**From:** Amanda Scholes on behalf of Planning.Responses  
**Sent:** 25 September 2018 08:28  
**To:** Planning Scanning  
**Subject:** FW: A/111/18/DOC

**From:** Juan Baeza  
**Sent:** 19 September 2018 16:55  
**To:** 'Anna Gillings'  
**Cc:** Anita Gardner; Emma Patchell; Mark Warwick  
**Subject:** RE: A/23/18/DOC - Broadlees, Dappers Lane, Angmering

**From:** Mark Warwick  
**Sent:** 05 September 2018 17:12  
**To:** Anita Gardner  
**Subject:** A/23/18/DOC - Broadlees, Dappers Lane, Angmering

TREE PROTECTION (Plan 3A)

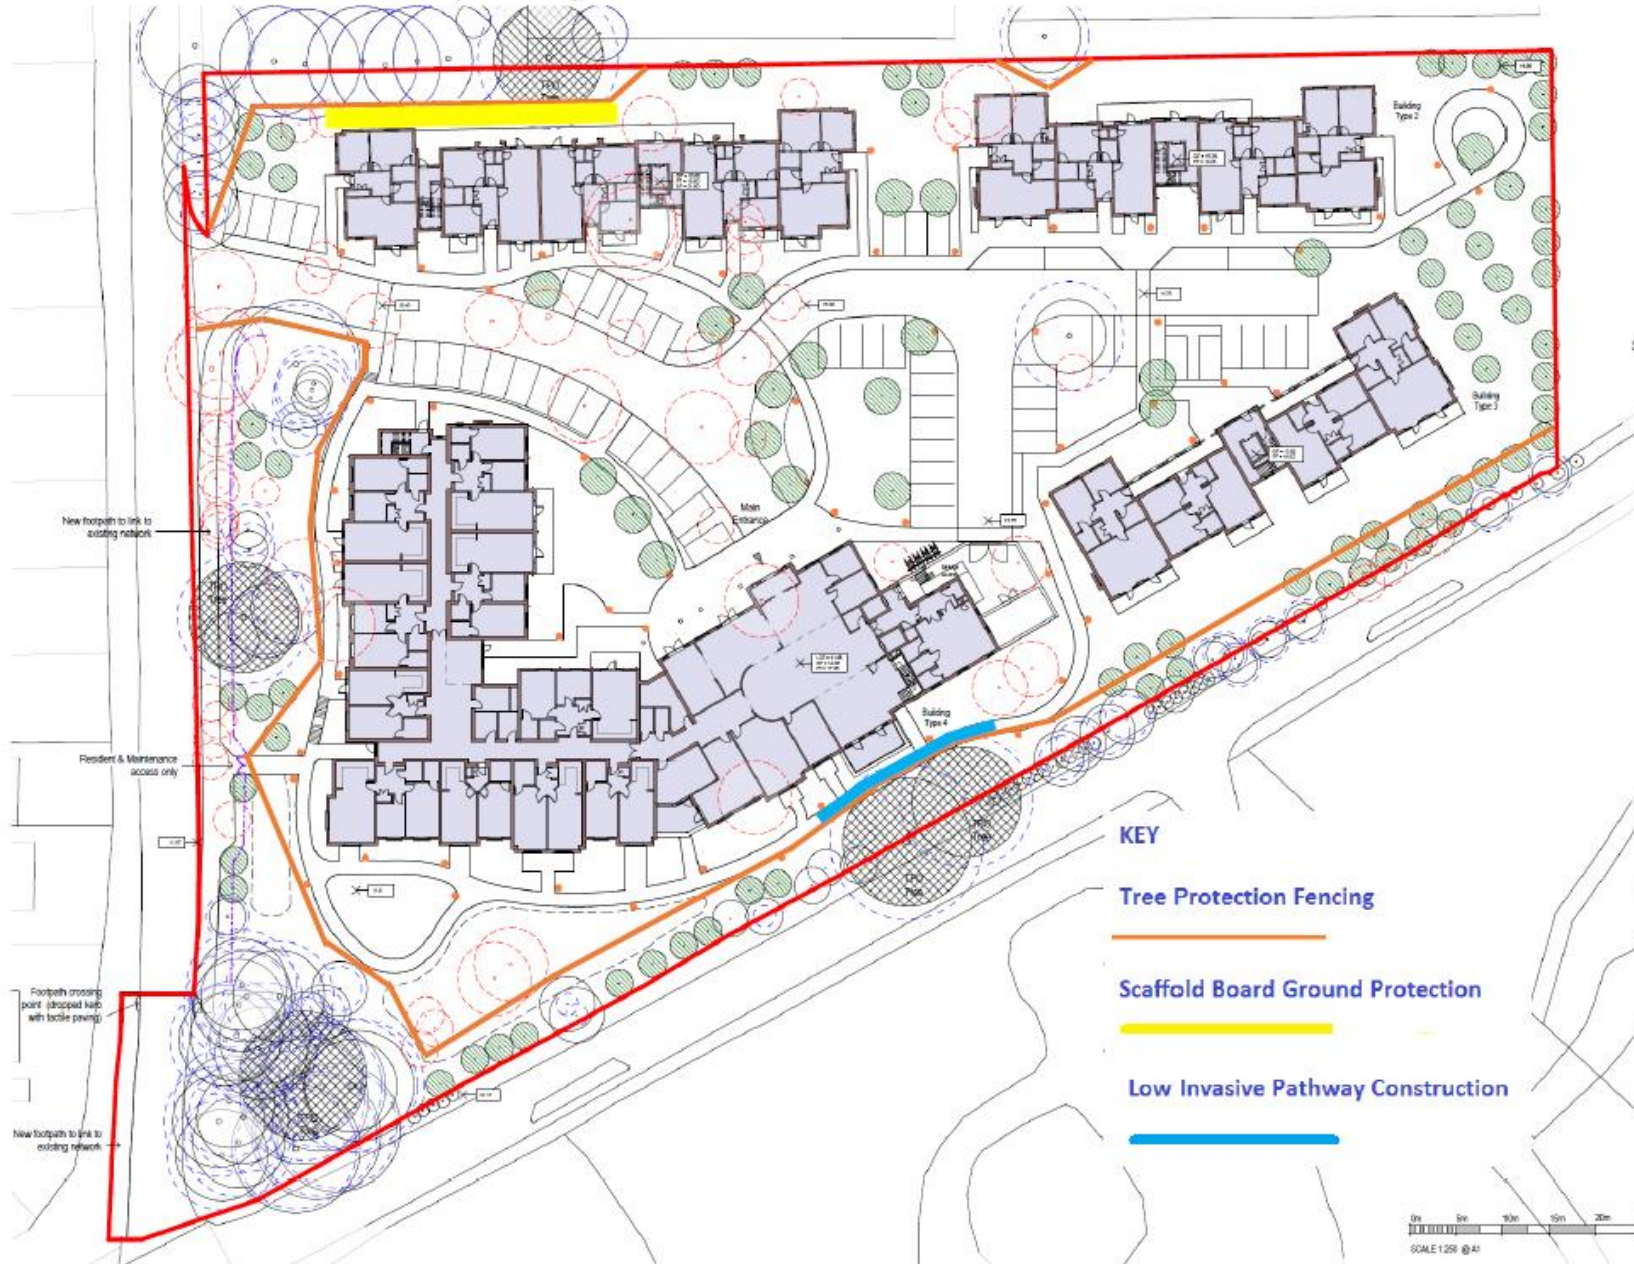
The details required from Mark requested that a gap in the fencing is fixed and that the ground protection area shown in plan 3A to be put into place to the NW corner. I am pleased to advise that this has now taken place and both measures are now on site. Please see the photos below to confirm this.

1. There is a gap in the fencing (mesh panel required) which permits access to trees, at least one of which appears to be the subject of an Order (TPO). This needs to be secured so as to provide an effective Construction Exclusion Zone and remove potential for soil contamination/disturbance.
2. Ground Protection as shown in Plan 3A is absent at the NW corner of the site. Again, there are trees of value here at least one of which appears to be the subject of an Order (TPO). This needs to be in place before I am comfortable that any demolition work can proceed.
